Response to Submissions - Relocation of the Administration Centre at the Calga Sand Quarry

May 2012

R.W. CORKERY & CO. PTY. LIMITED

Figure 3.1
LAND OWNERSHIP AND
SURROUNDING RESIDENCES

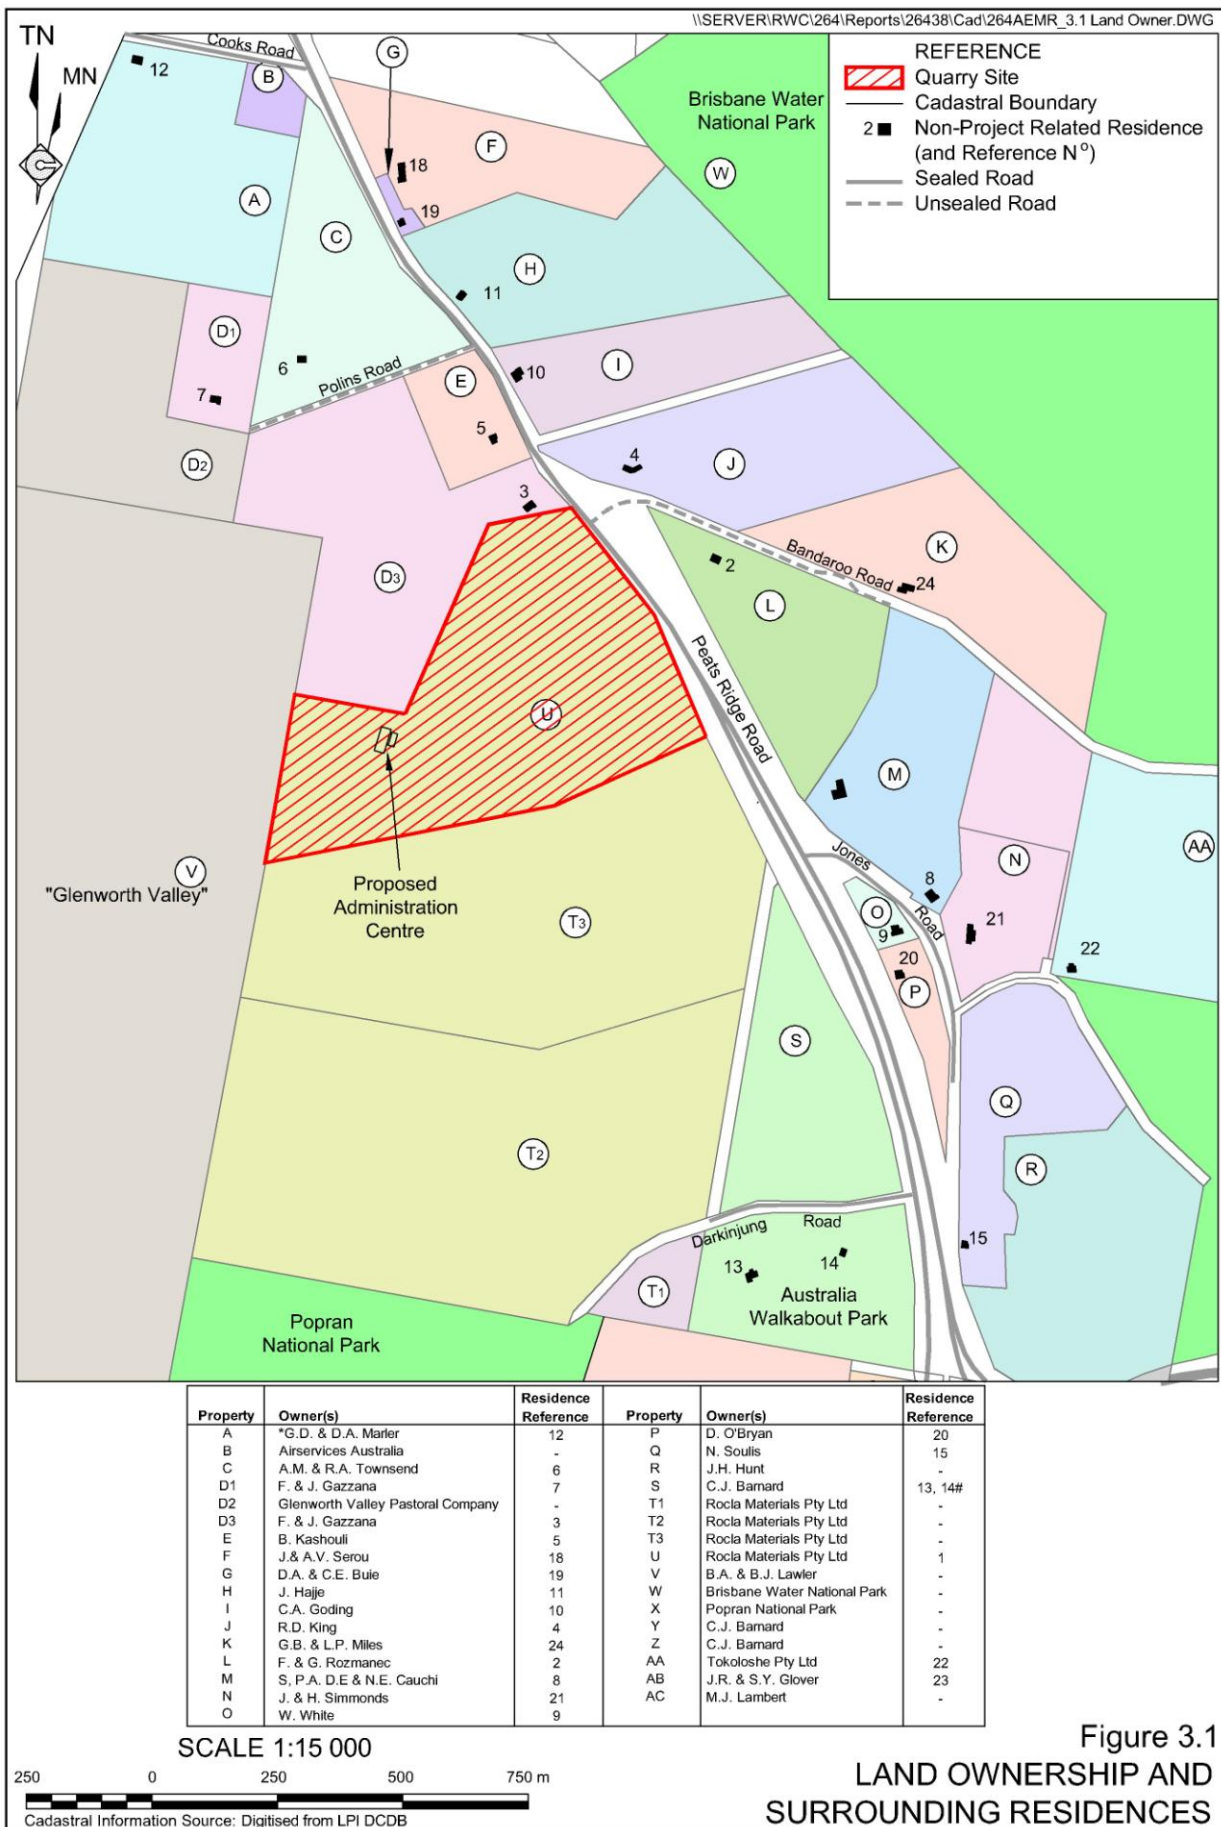
Issue / Response
PUBLIC SUBMISSION – AUSTRALIAN WALKABOUT WILDLIFE PARK (AWWP)
Issue 1: Impact on Surrounding Residences
A. 'It is important to note that the EA suggests that Walkabout Park is situated only south of Darkinjung Road, whereas Walkabout Park extends all the way along Peats Ridge Road (ALL of property 'S' in Figure 3.1).'

Response <i>It is noted that both parcels of land referred to are owned by the Australian Wildlife Walkabout Park (via C.J. Barnard), however, the Park itself is currently defined by an electrified fenced boundary south of Darkinjung Road.</i>
